PLANNING APPLICATION REPORT

REF NO: P/47/11/

LOCATION: 52 East Front Road
Pagham

PROPOSAL: Single storey extensions

For	Date	Dwg by	Revision
Mr and Mrs Evers	24.05.2011	sk	C
Title	Scale	Project no	Dwg no
PROPOSED LAYOUT, ELEVATIONS AND SECTION A-A	1:50	126	P2

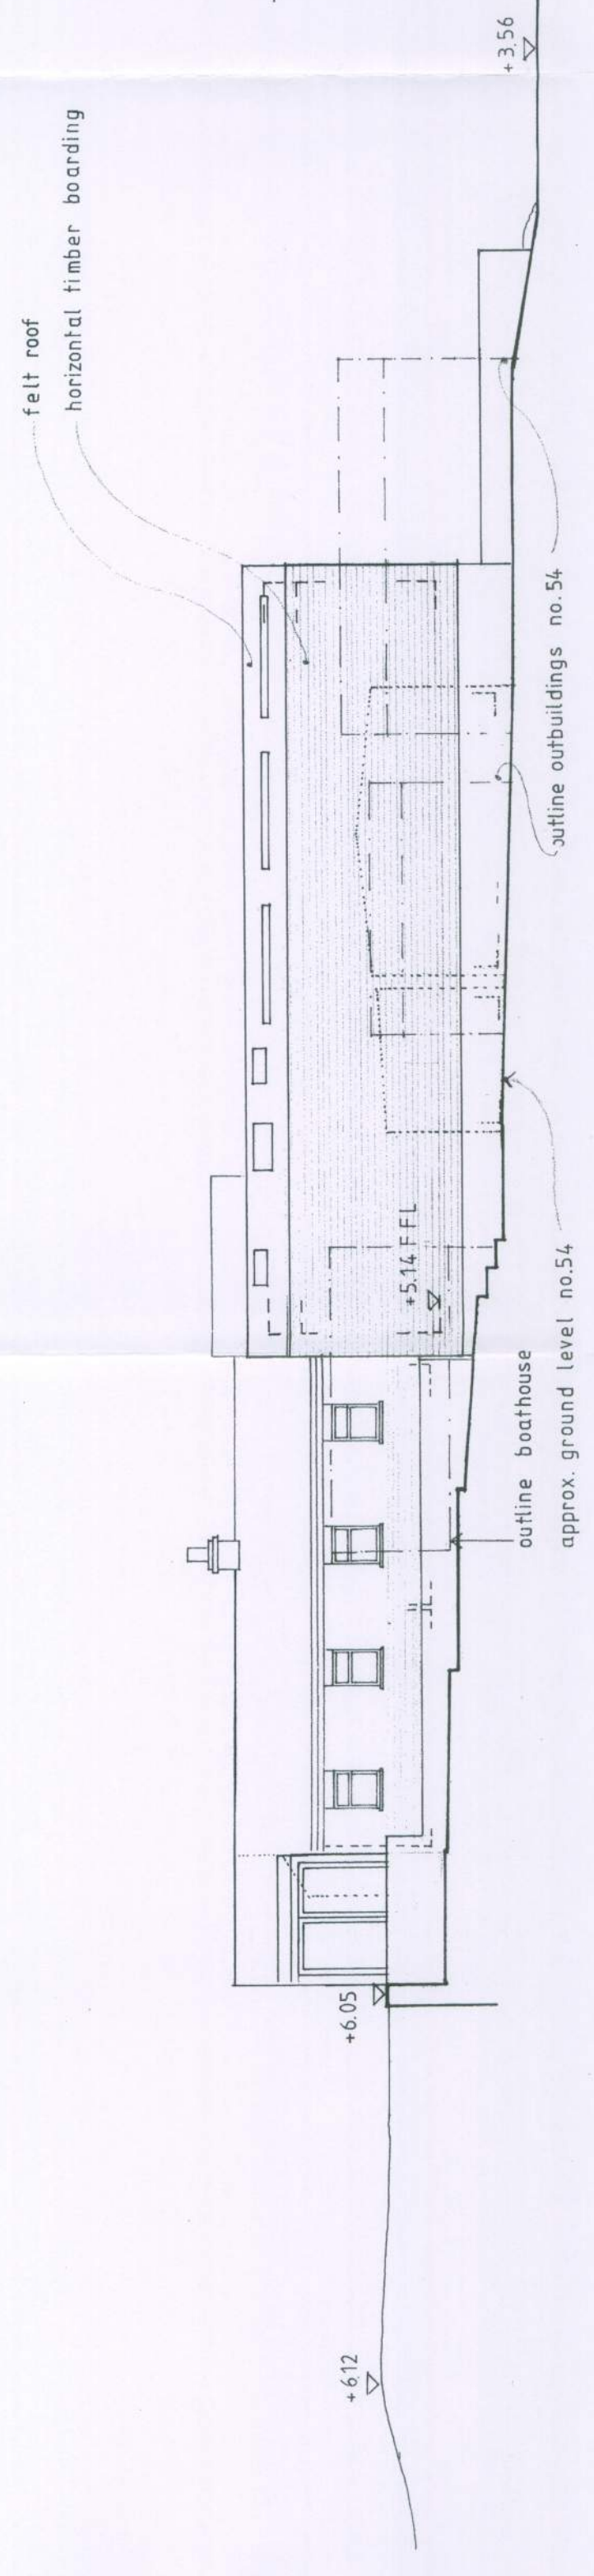
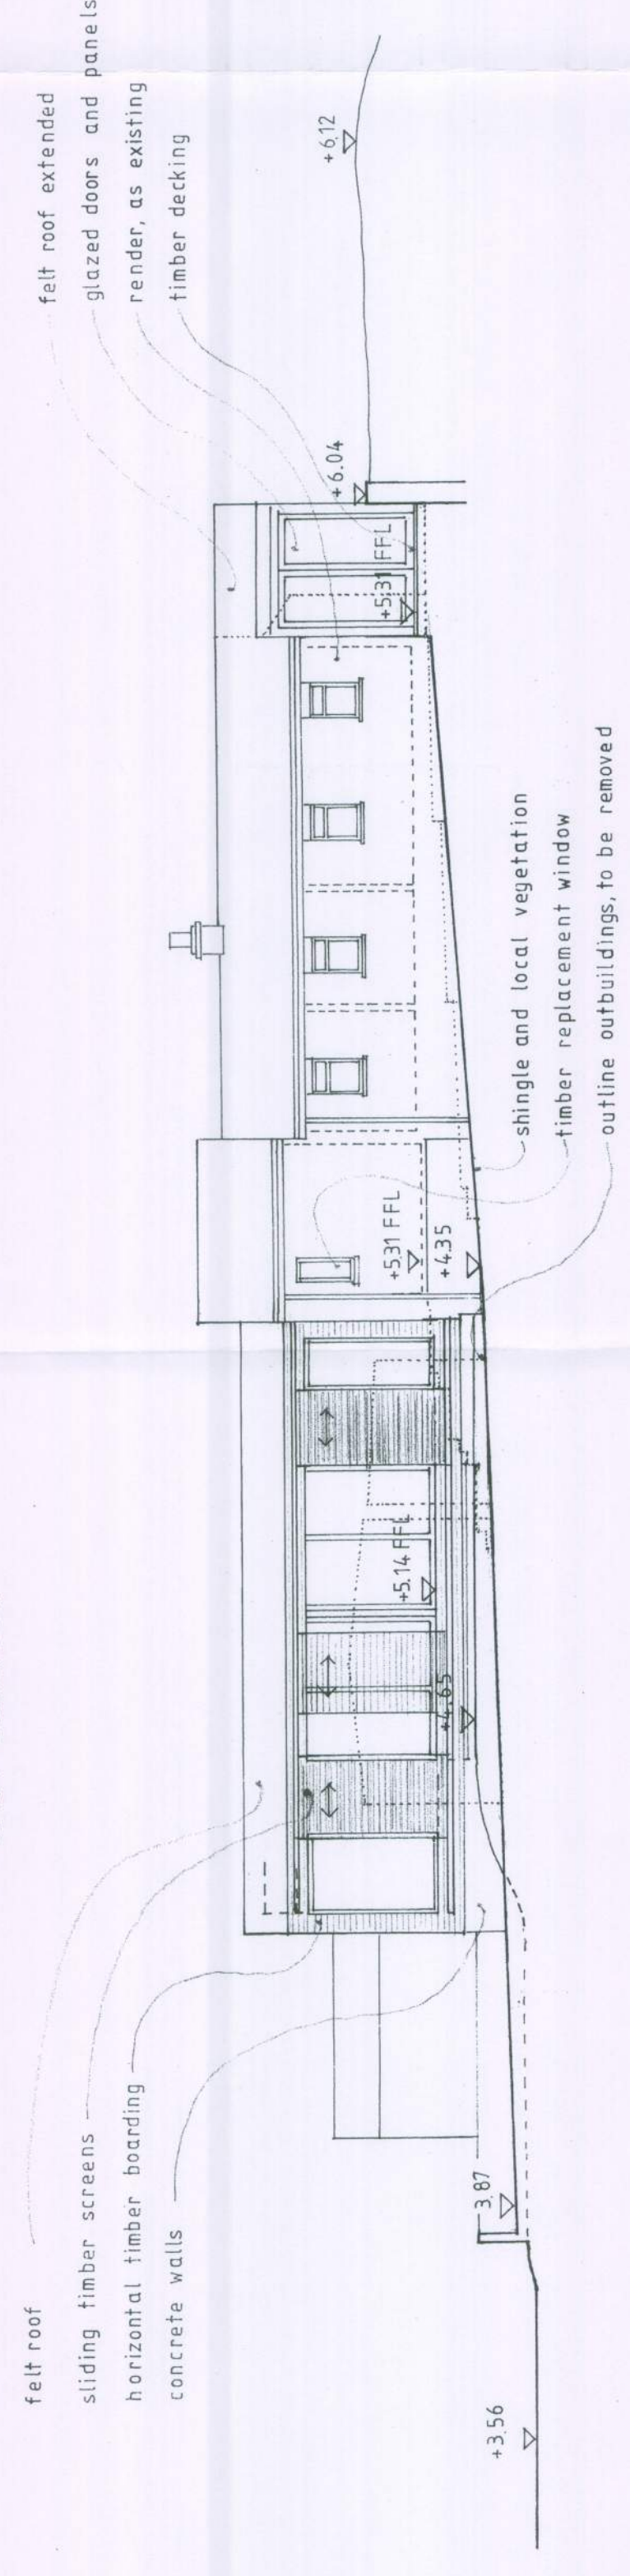
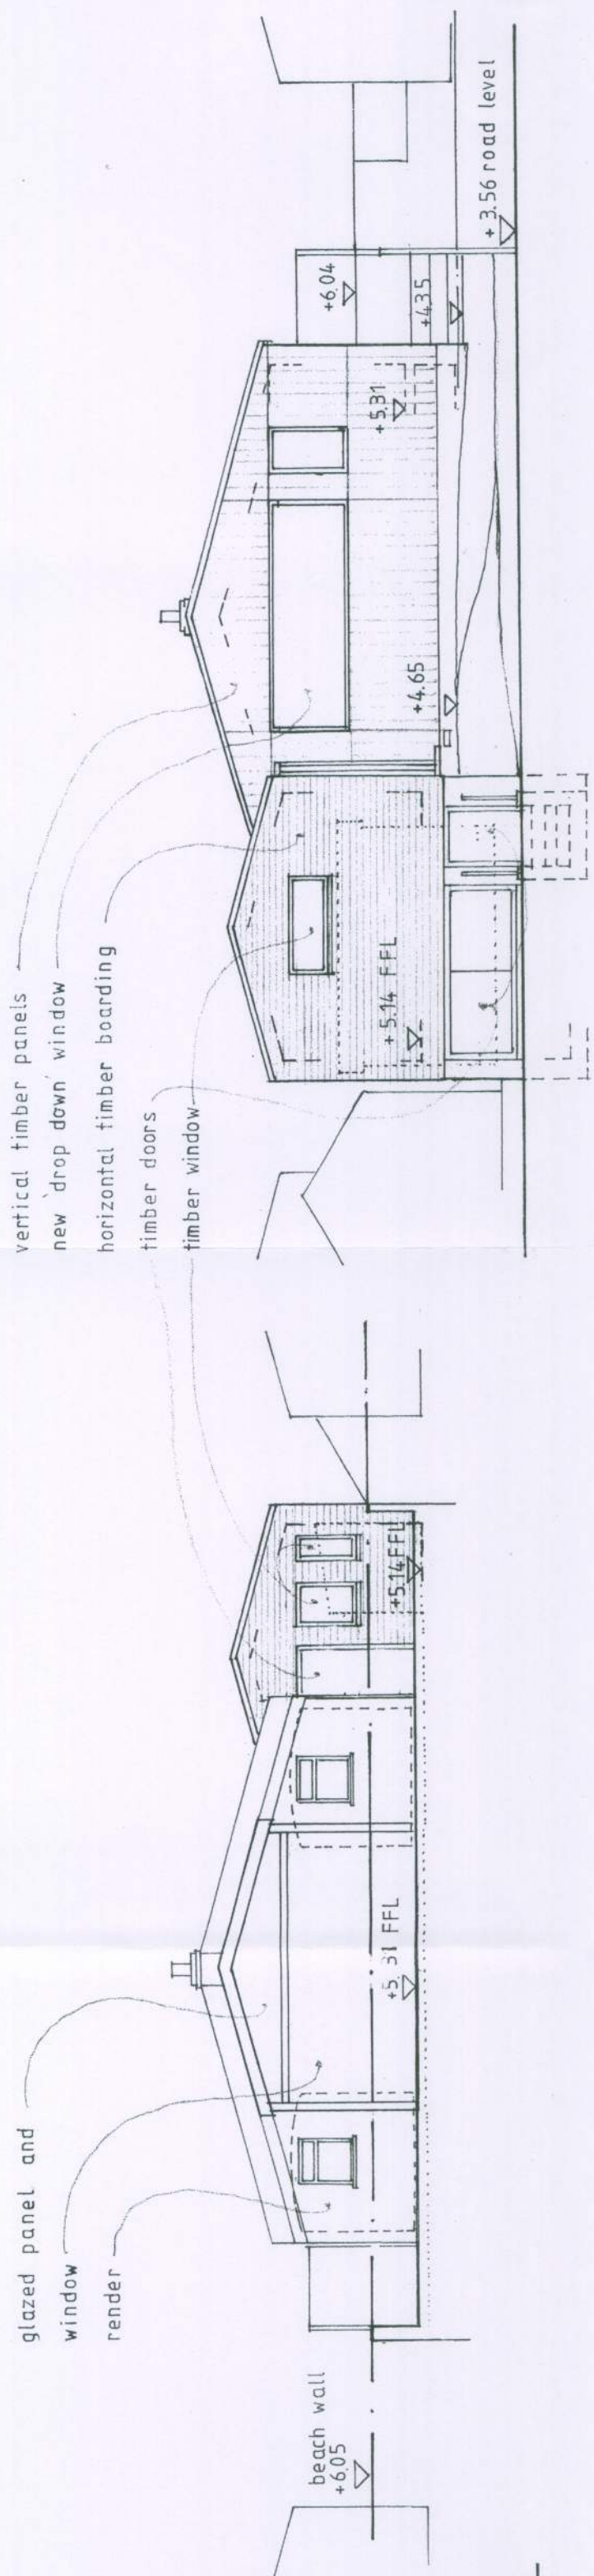
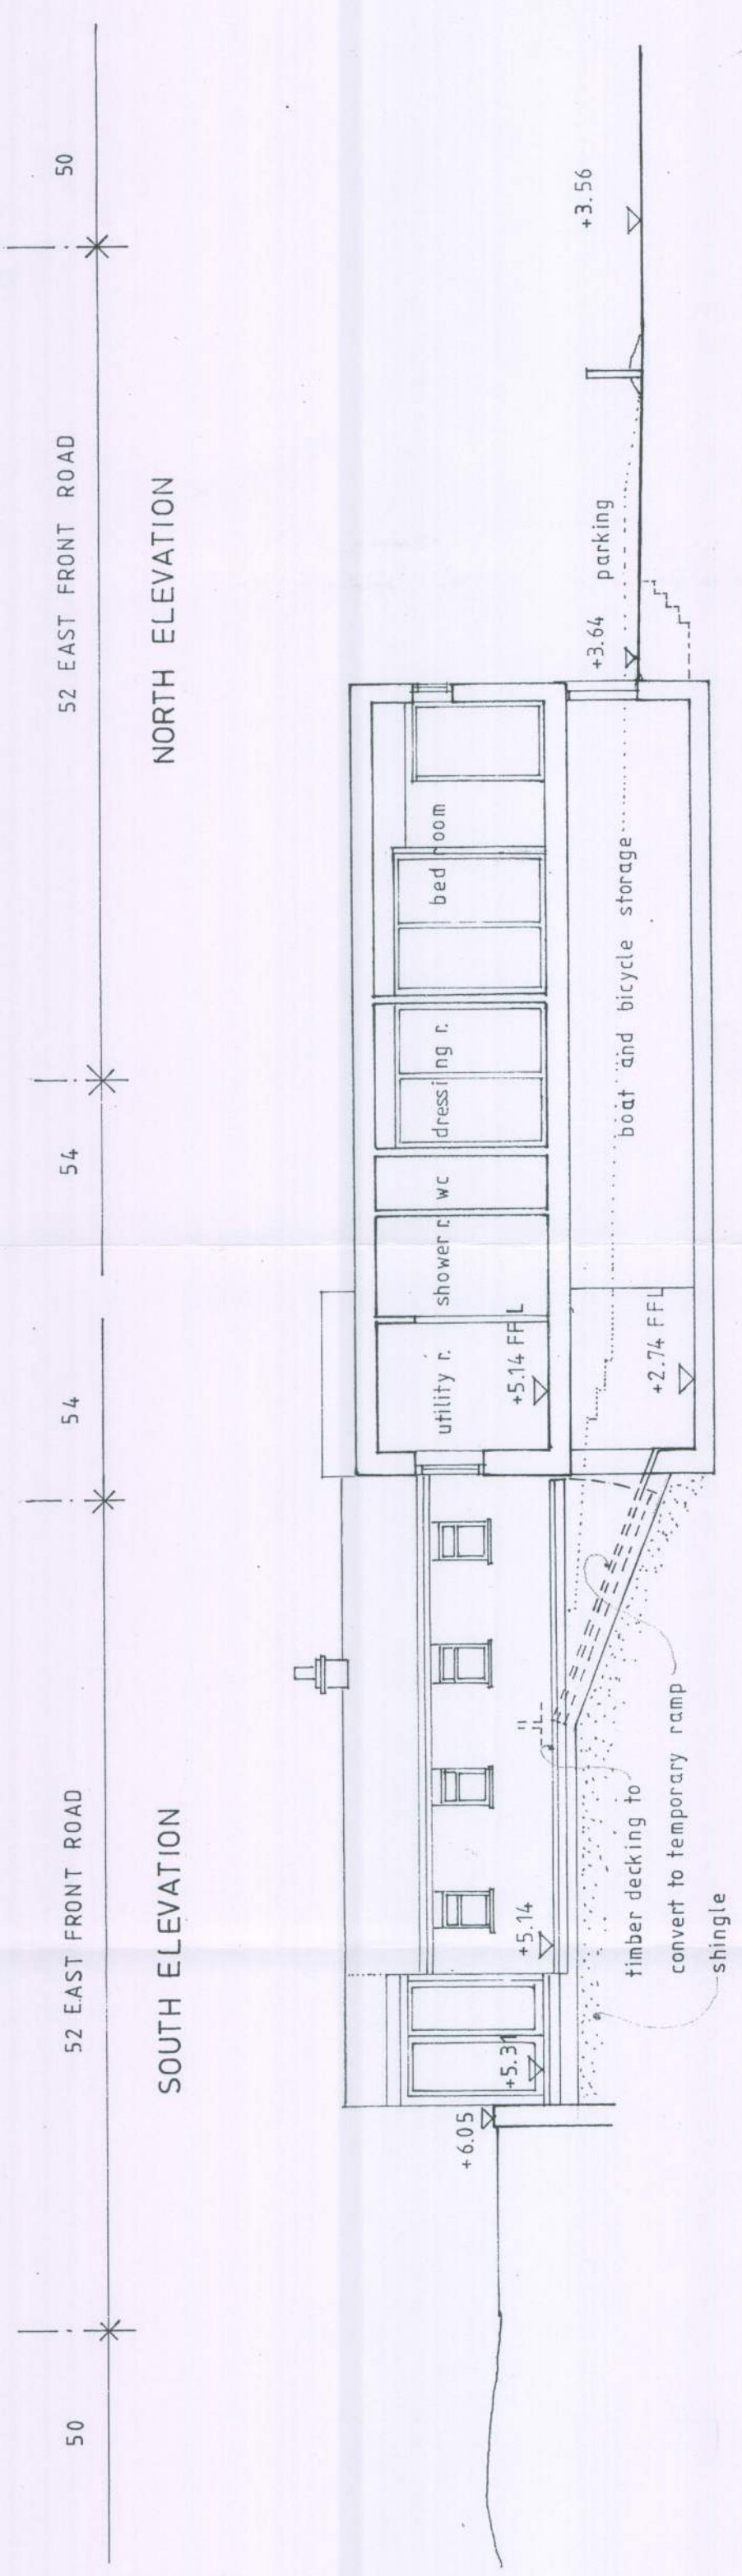
Although the side extension does remain single storey in height and appearance, with the roof angled away from the north boundary, the proposed additions would be significantly greater in height to existing building as well as the approved scheme (P/99/08). The addition would have an overall height of 4.3m which extends along the eastern boundary for some 12.7m. The overall depth of the addition coupled with its height, projecting some 1.6-1.8m above the outbuildings within the front garden area of 54 East Front Road is considered to have a detrimental affect upon the neighbouring property by way of an overbearing affect and loss of light. In terms of residential amenity the proposed addition is therefore considered to be unacceptable.

With regard to visual amenity, the proposal is also considered to be unacceptable. The previous planning approval with the increase in height of the host dwelling, meant that the extension appeared visually subservient with the ridge height set well below that of the host dwelling. The proposed addition is considered to conflict with this. Its height, scale and depth is considered to compete with that of the host dwelling with only a height of 200mm the difference between ridge height of the host dwelling and that of the extension. As such it is not considered to appear visually subservient or integrated with the host dwelling and therefore conflicts with the requirements of policy DEV19 of the Local Plan.

The application also proposes 6No. roof lights with the eastern roof slope of the extension. The site is located within the Pagham Area of Special Character in which development within roof slopes is not encouraged. The amount of roof lights proposed mean that they would appear as prominent feature when approaching the site from the east. These would appear out of character and in conflict with the objectives of the designated Area of Special Character. It is also considered that the introduction of roof lights across the width of the eastern roof slope would set an unwanted precedent for unsympathetic roof lights within the street scene and emphasise the unacceptable scale of the extension. Furthermore it is considered contrary to the character and development criteria set out in the Pagham Village Design Statement in relation to preserving the character of the area.

The proposed height, scale and appearance of the proposed extension fails to integrate and appear subservient to the host dwelling detrimental to both the character and appearance of the host dwelling and locality. The height and depth of the extension would also have a detrimental impact upon the residential amenity currently enjoyed by at the neighbouring site, 54 East Front Road as the addition would be significantly higher than neighbouring outbuildings.

- 1 The extension by reason of its height and depth competes with the scale of the host dwelling, therefore failing the requirements of Local Plan for extensions to appear visually integrated and subservient to the host dwelling. The addition is therefore detrimental to the appearance of the host dwelling as well as the visual amenities of the area which is defined as an Area of Special Character. The development would therefore be contrary to policies GEN7 DEV19 and AREA1 of the Arun District Local Plan.

- 3 The extension, by reason of height and length, would be detrimental to the residential amenities of occupiers of 54 East Front Road because of the loss of light and overbearing effect. The development would be contrary to policies GEN7 and DEV19 of the Arun District Local Plan.

SECTION A-A

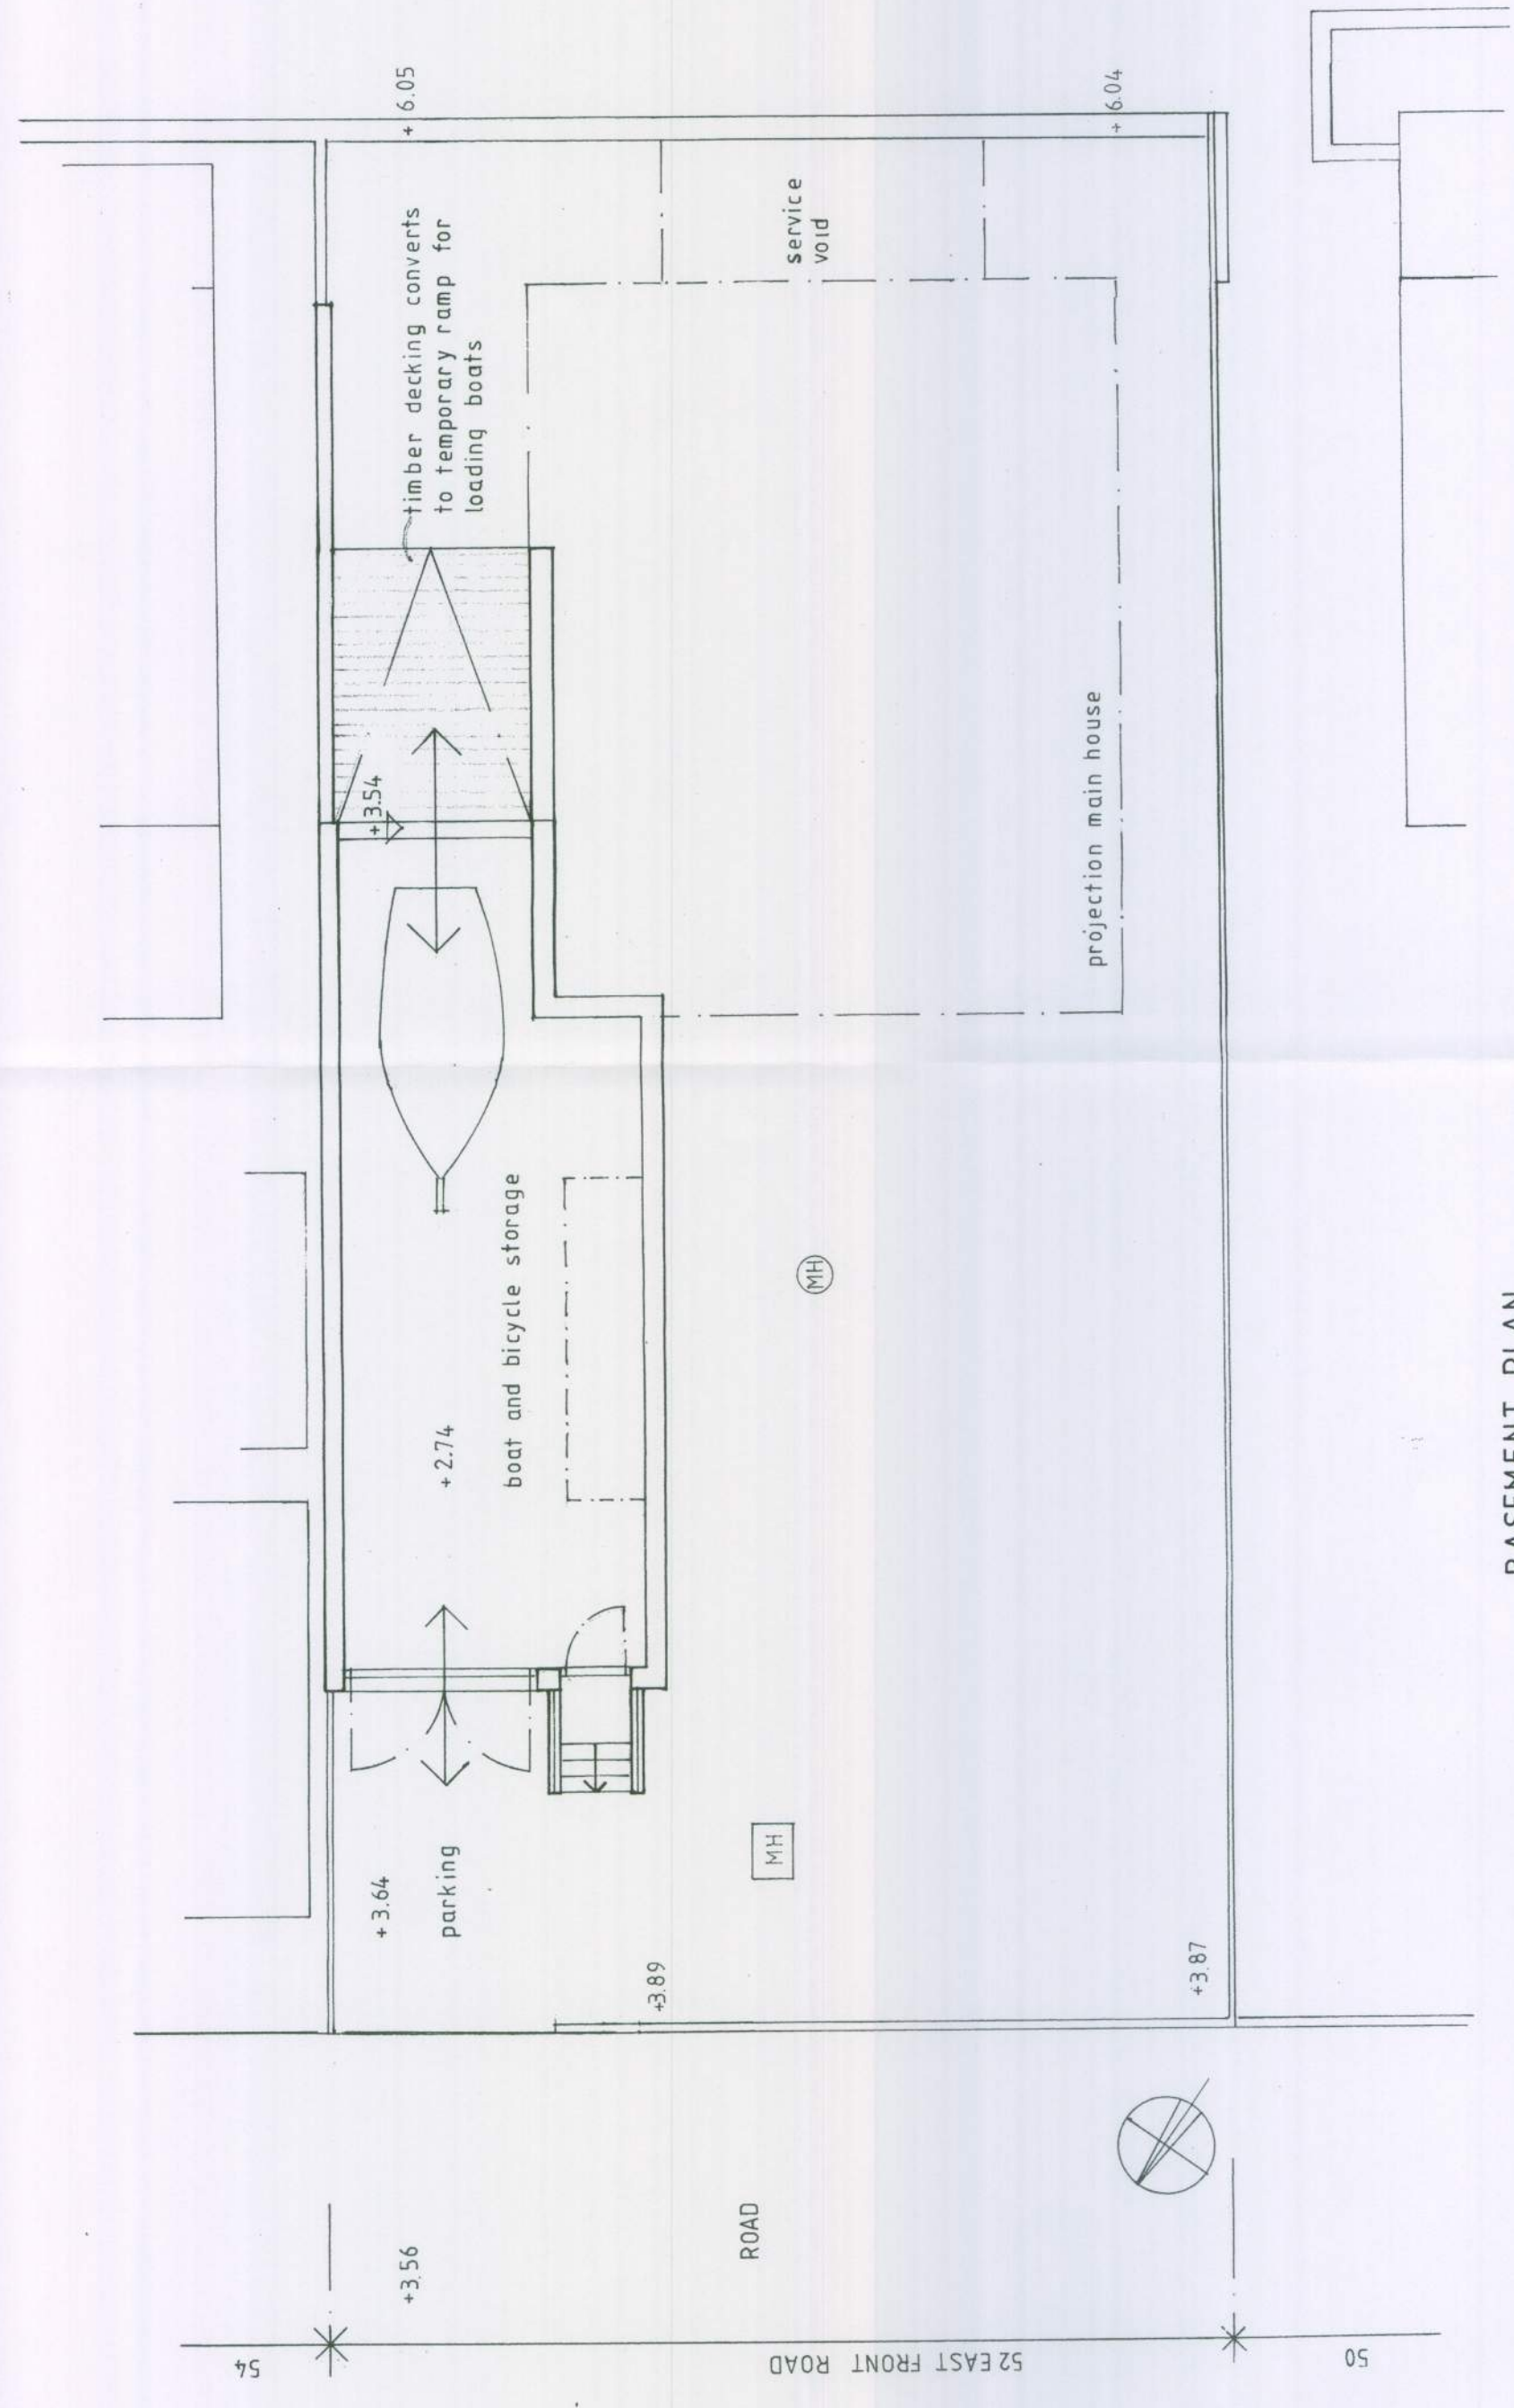
With regard to residential amenity, it is recognised the side extension would abut a site boundary, and that, because of the provision of a basement store below the extension will be of a greater height than it would be otherwise. This creates a potential for a greater degree of overshadowing onto the neighbouring property to the east.
